TII26-135821

Re: Strategic Infrastructure Development Application for a 220kV Substation and 220kV underground electricity cabling connecting to the existing Cashla 220kV substation in the townlands of Rathmorrissy, Pollnagroagh, Moanbaun, Castlelambert, Knocknacreeva, Caraunduff, Caherbriskaun, Lisheenkyle East, Barrettspark, Cashla, Athenry, County Galway

ACP case ref. VA07.324162

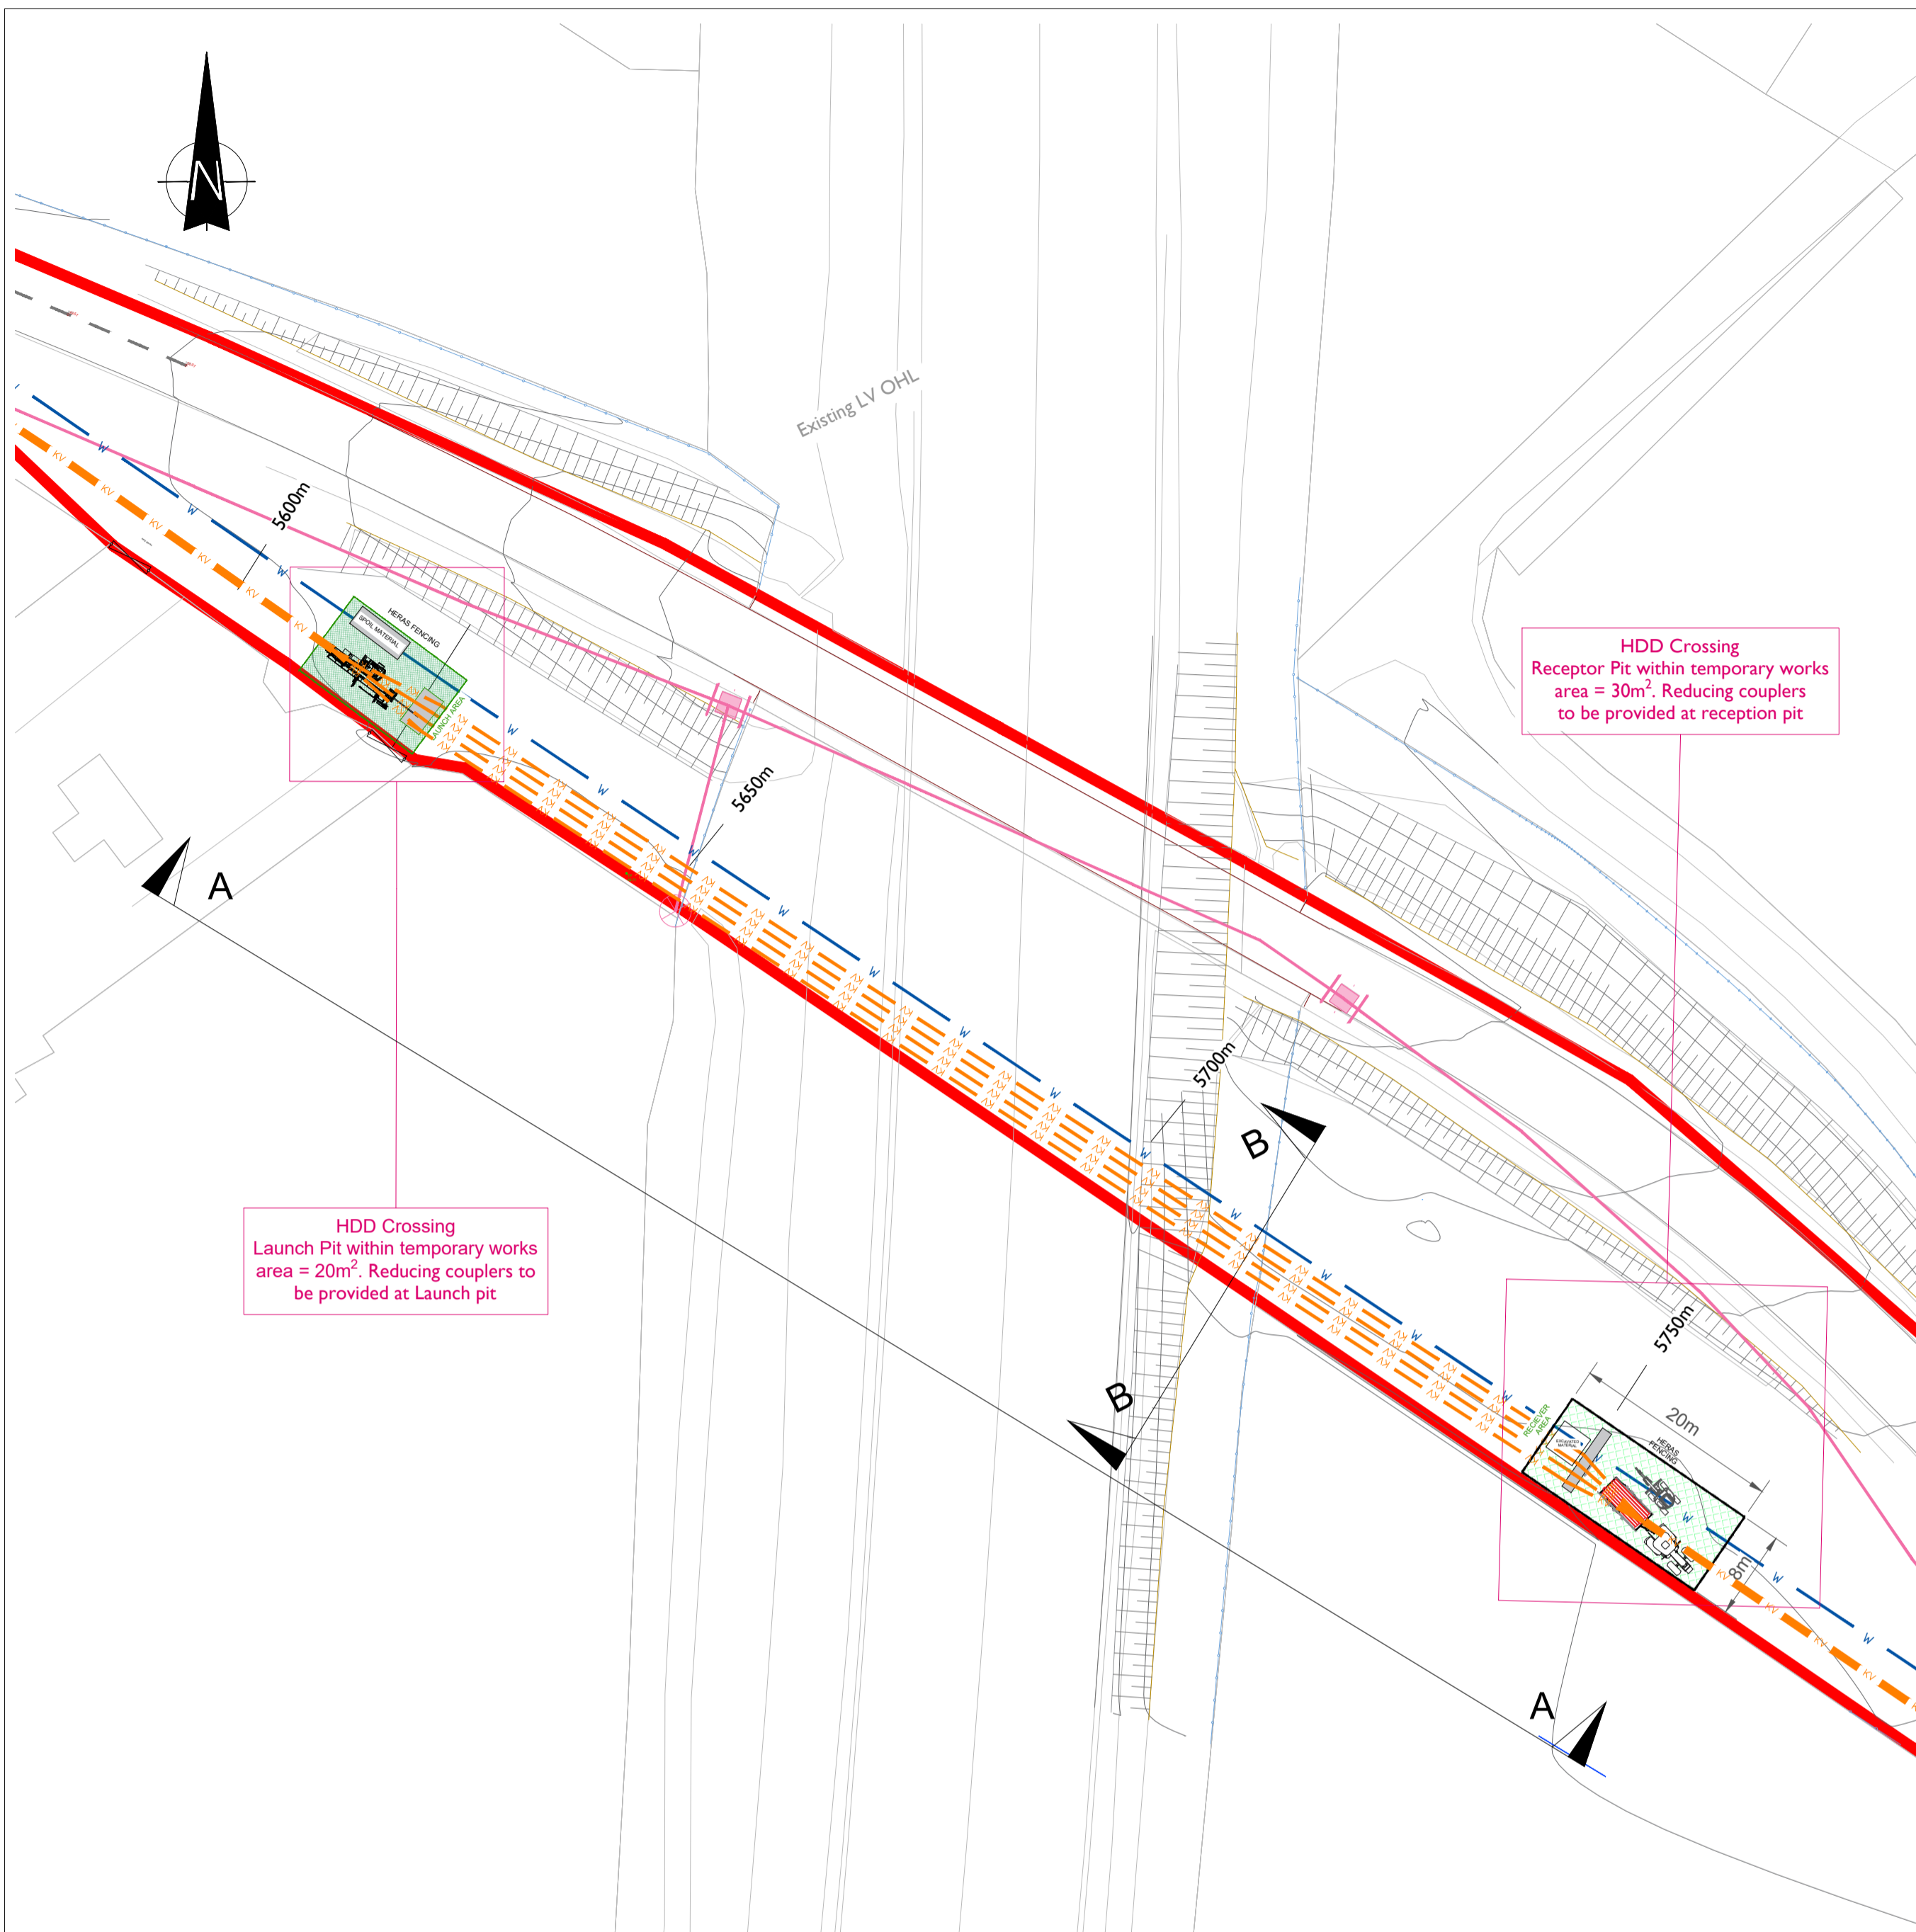
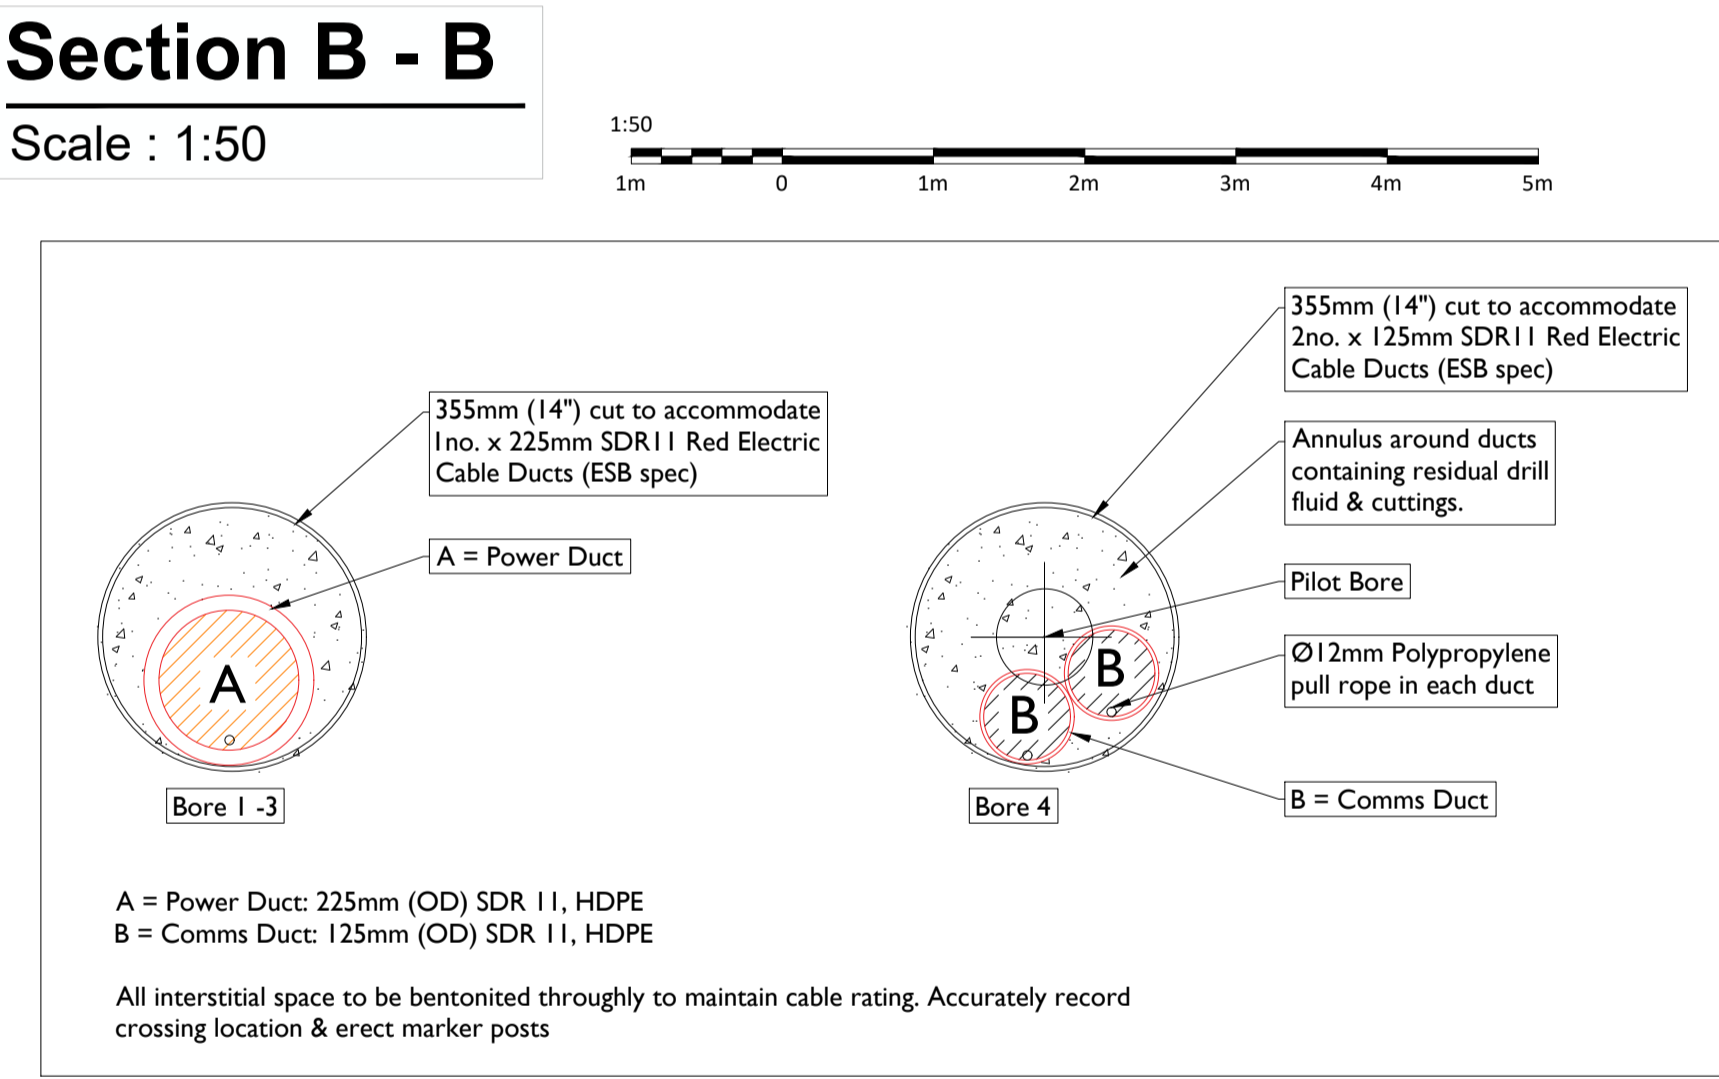
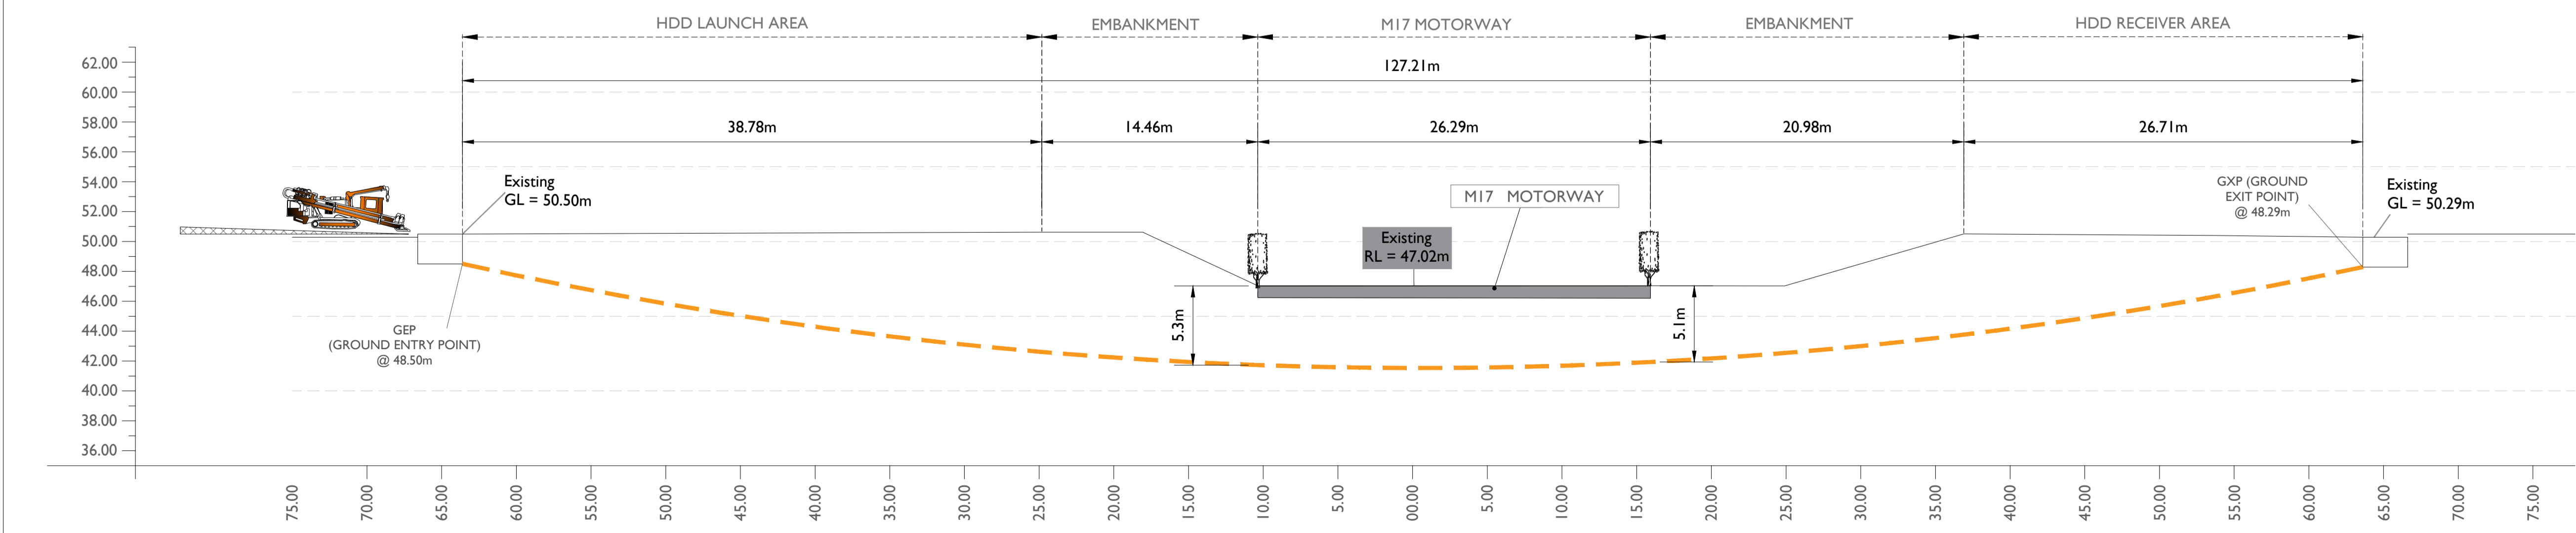
The grid connection routing to the Cashla 220kV substation details 3 proposed motorway crossings, one of the M18 parallel to local road L3103 and two (no.) of the M6 parallel to local road L7109 and secondly parallel to local road L7108. All proposed motorway crossings are by HDD trenchless technology.

In addition, TII notes that the Gannow Windfarm application proposes only one motorway crossing whereas the subject application for the Cashla Peaker Power Plant proposes three separate HDD Crossings of the motorway network, one no. of the M18 and two no. of the M6.

2.3.1 Requirements for HDD Crossing of the Motorway Network

General requirements for directional drilling under a motorway include;

- The launch and reception pits for the crossing are located outside the Motorway boundary,
- The cabling/pipeline will be installed at such depth so as not to conflict with the drainage for the Motorway,
- Neither the Works nor the cable crossing will damage or interfere with the Motorway,
- Any maintenance and/or future planned upgrades of the cabling/pipeline at the crossing location can be carried out without access to the motorway boundary,
- There are no bolted joints in that part of the crossing within the motorway fence-line,
- A pre and post construction survey shall be required along the length of the crossing over the extents of the motorway boundary,
- Specific requirements may also arise for these proposed works.
